From: [REDACTED]
Sent: 29 August 2023 17:48
To: Planning
Subject: FAO: Emily Pickup - Planning Application No: 3/2023/0627

Following [REDACTED] 95 King Street, Whalley, on the 22nd August 2023 I would like to make a few comments / concerns.

Address of Development: 95,King Street, Whalley,BB7 9SW

Proposed Side Elevation (North Facing)
1:50 Scale

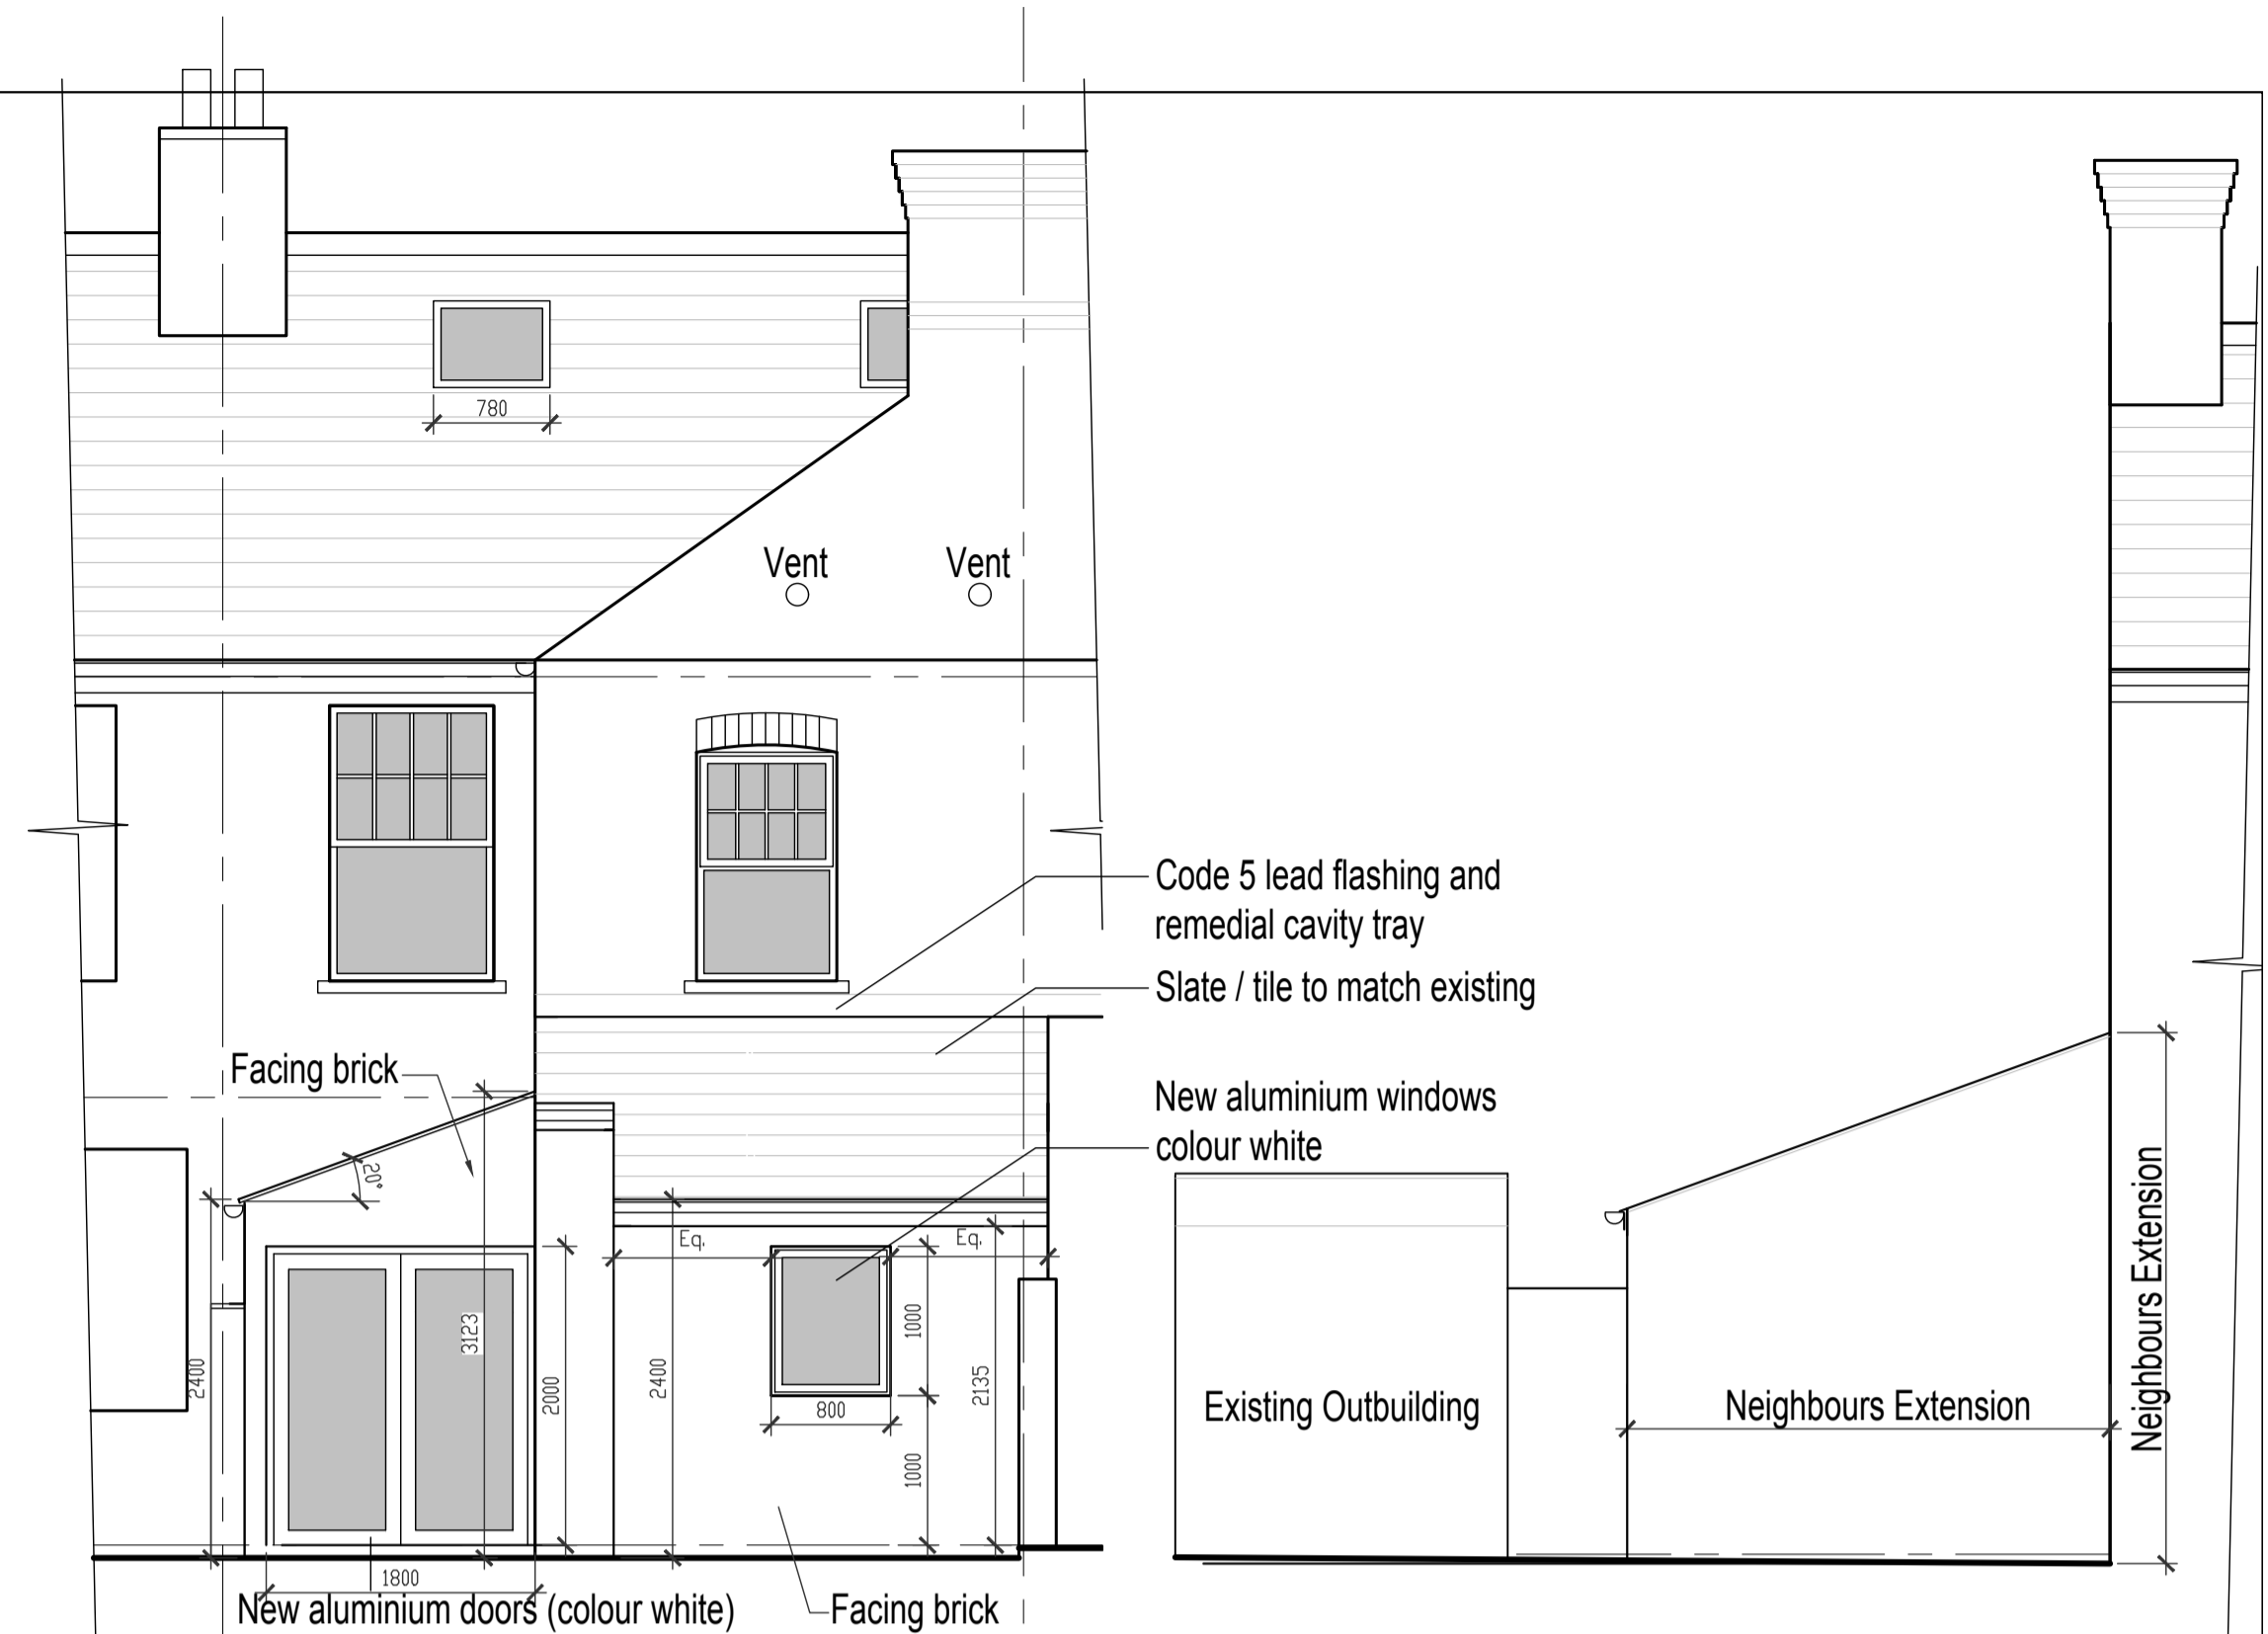
1. The plans are extremely deceptive. The proposed side elevation (North facing) shows the proposed extension roof to meet the existing garden wall which is 1580mm. However, the rear elevation (West facing) shows the proposed extension height of 2400mm. This is not only over 800mm higher than the initial plans which have already been refused by yourselves but will [REDACTED] I can only presume this is an error? Can this be clarified please.
